Application for a non-material amendment following a grant of planning permission.

Erection of 4 No dwellings & associated works. This application is a Departure from the Development Plan.

Reference number:	BN/39/20/PL
Date of decision	04/09/2020

DRAWING TITLE :  
PLOT 1:  
Elevations - Non-Material Amendment Submission

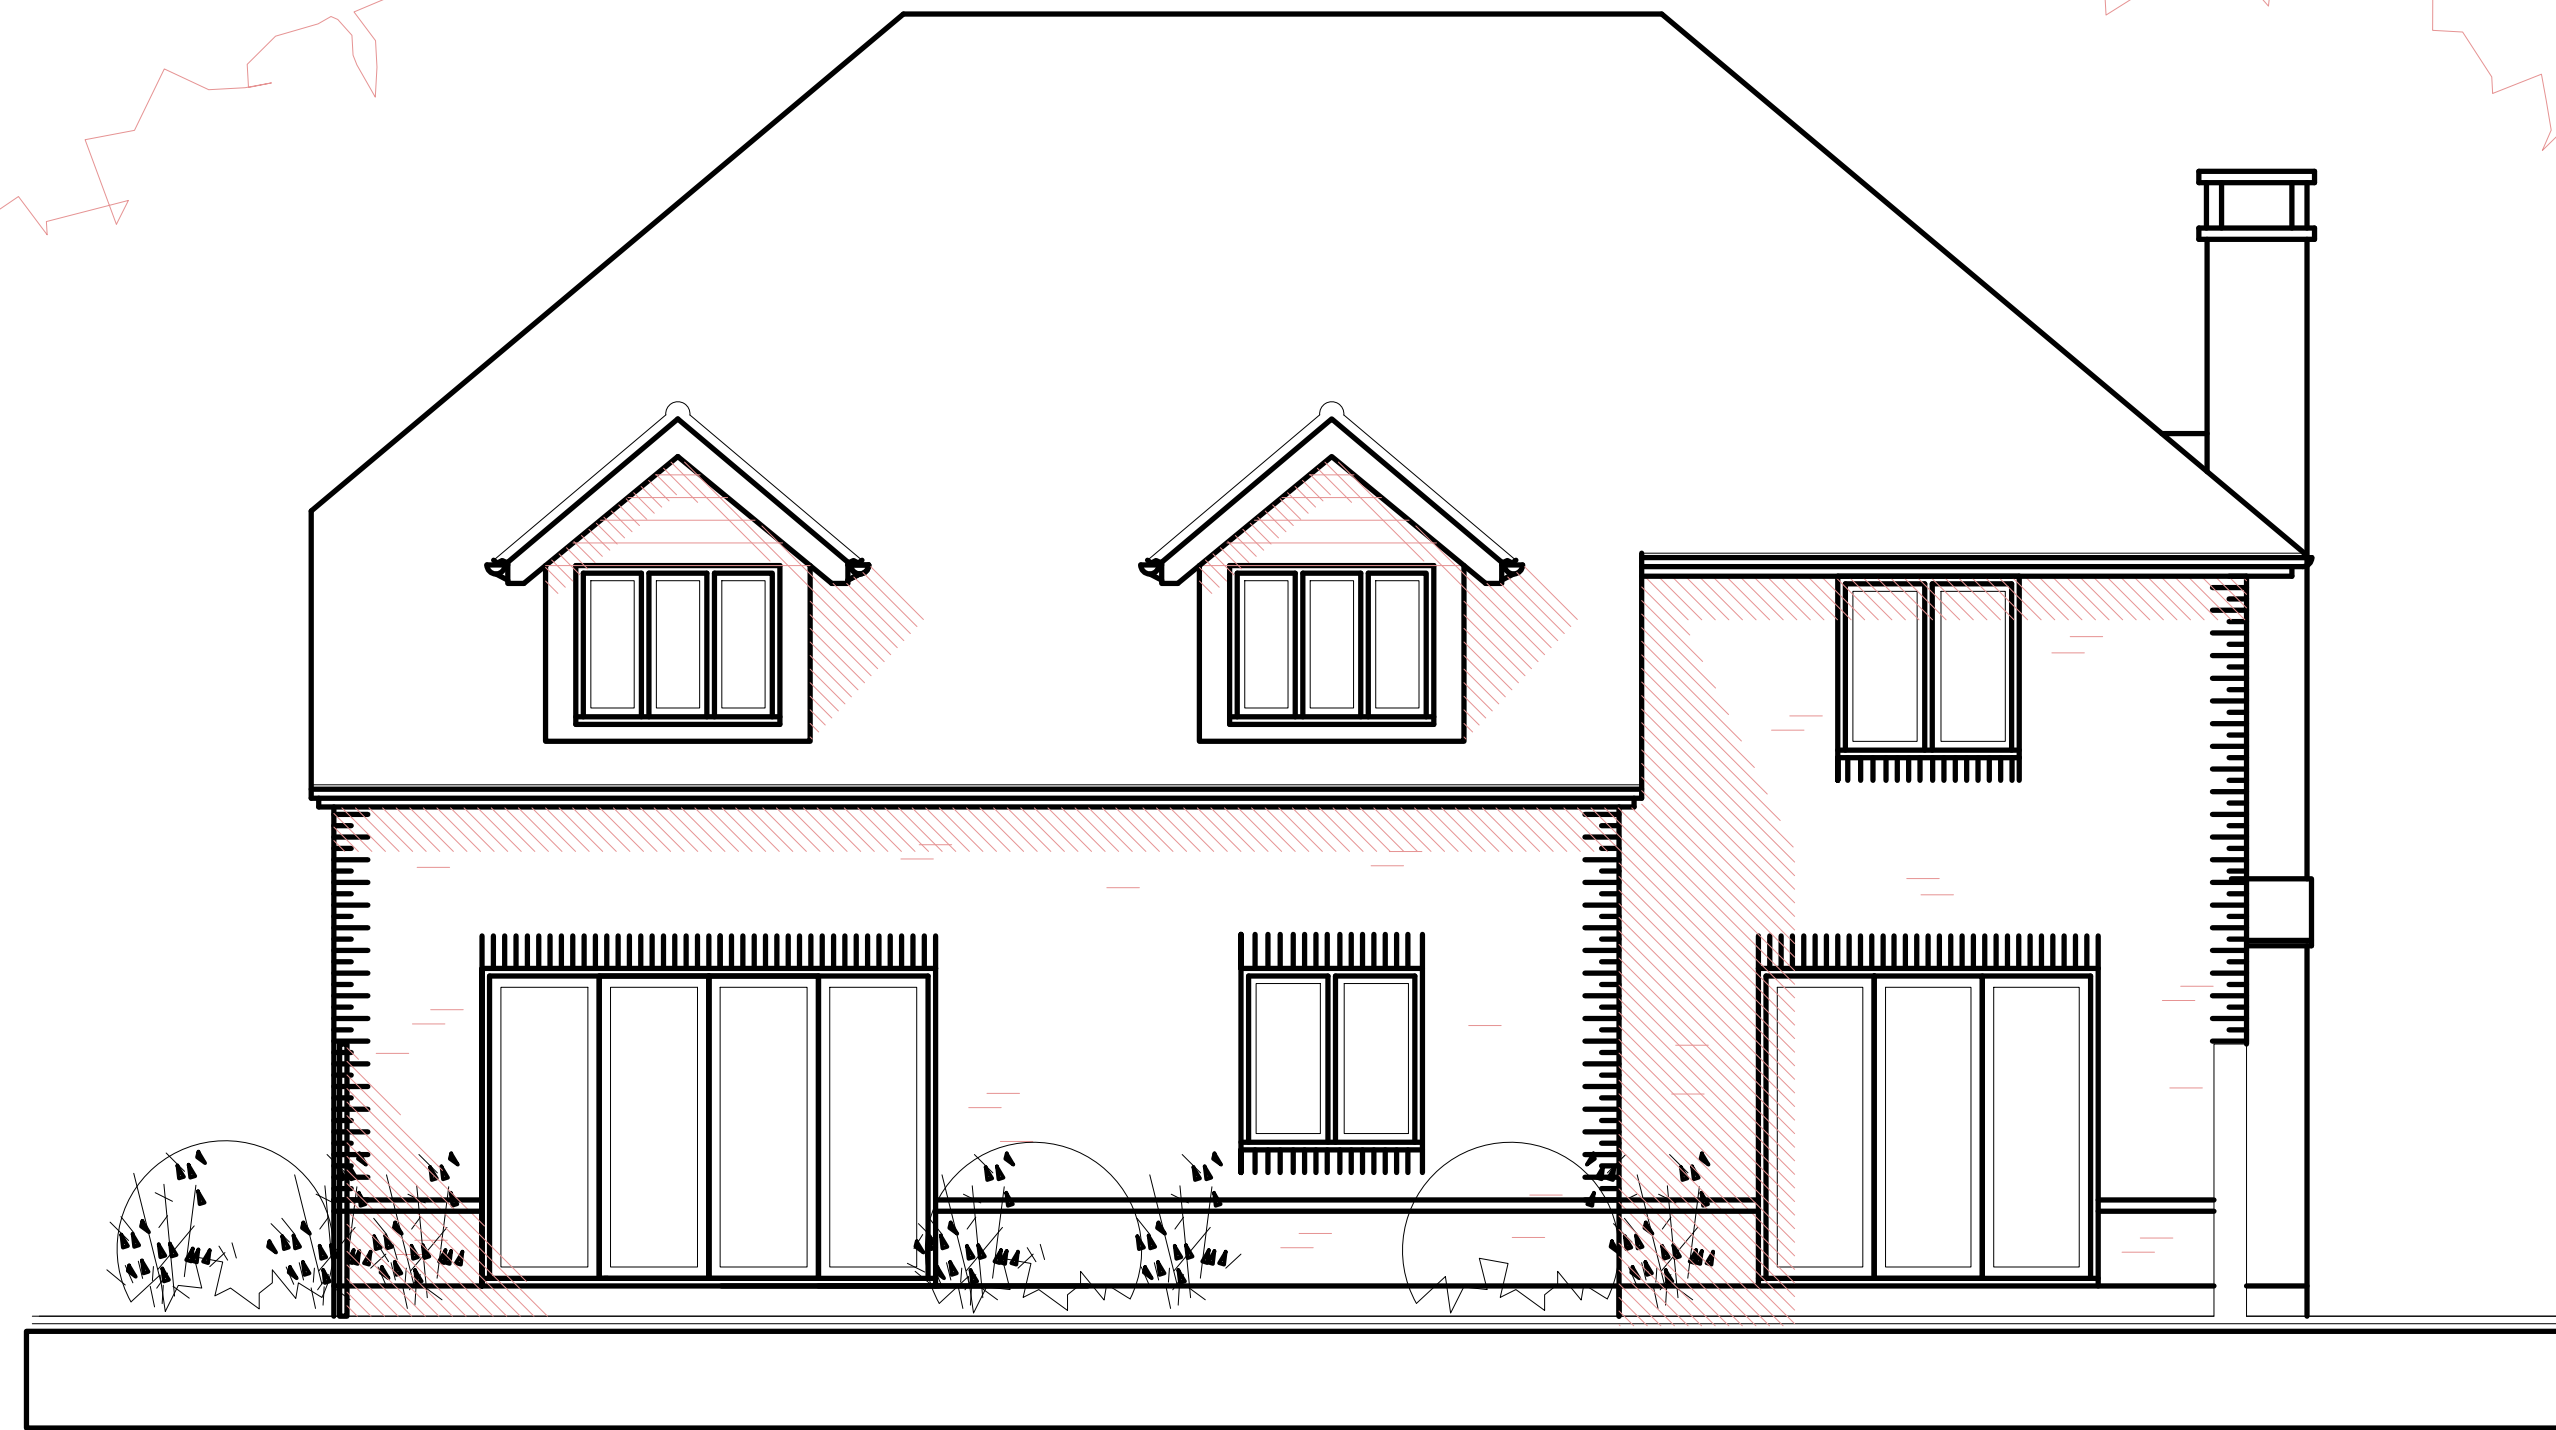
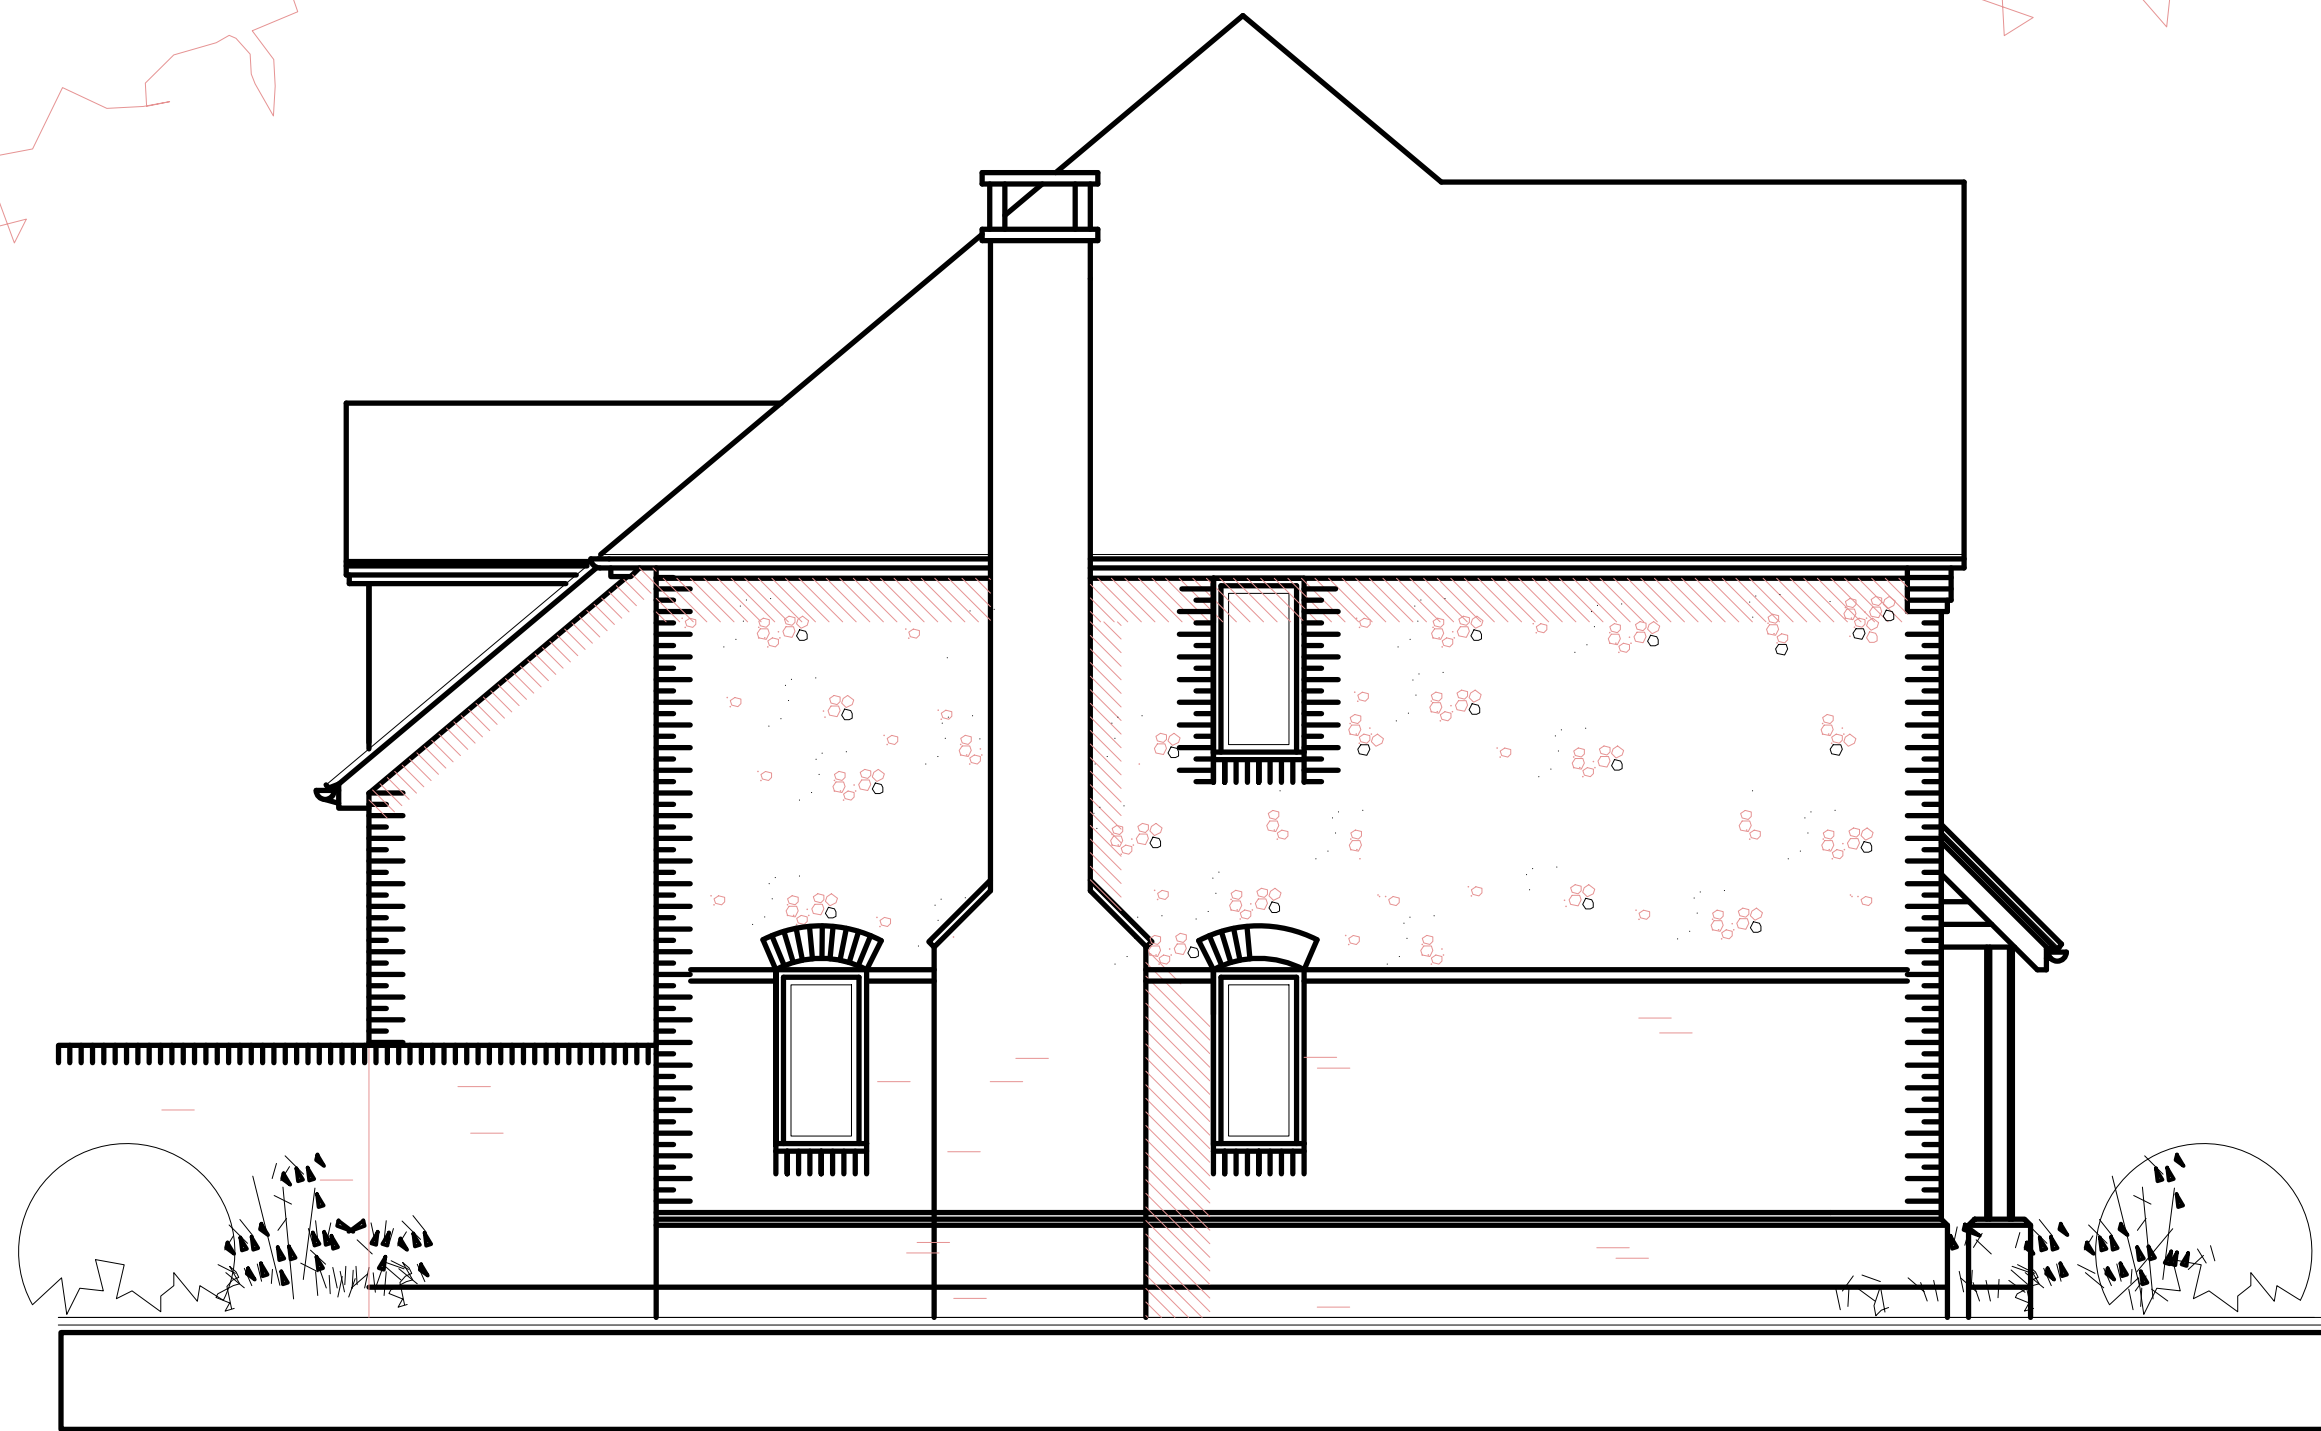
1. Road surface material to inner site drive changed from block paving to gravel matching the existing access track.
2. Plot 1 (internal amendments not impacting externally).
3. Plot 4 (internal amendments not impacting externally).
4. Plot 1 chimney handed to other side of dwelling.
5. Plot 1 stepped access introduced.
6. Plot 4 bulk of dwelling handed with chimney moved to external wall.
